CITY OF ALBUQUERQUE

March 8, 2018

**Re: Sage Ranch Subdivision
Erosion and Sediment Control Plan
Engineer's Stamp Date 2-27-18 (M09E025A)**

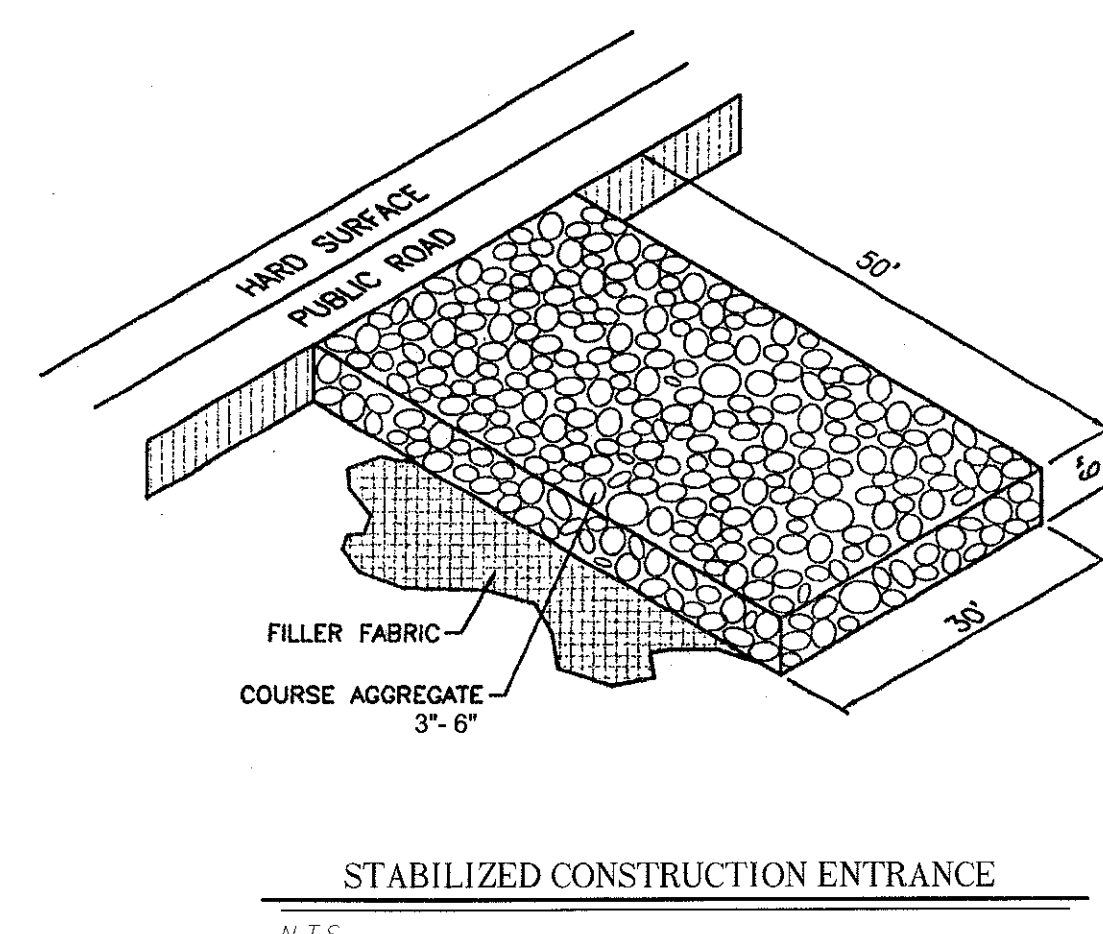
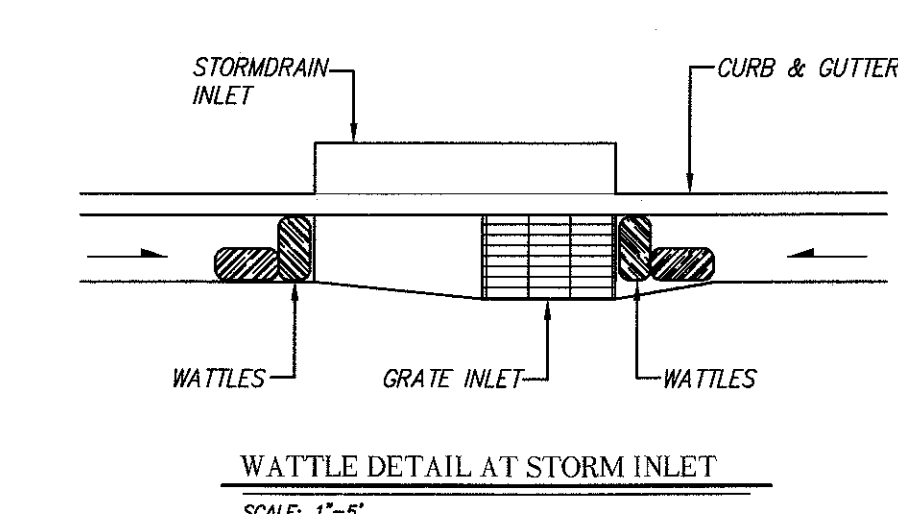
A mulch sock may be requested south of the storm drain work in Snow Vista Blvd. The determination will be made during a site inspection(s).
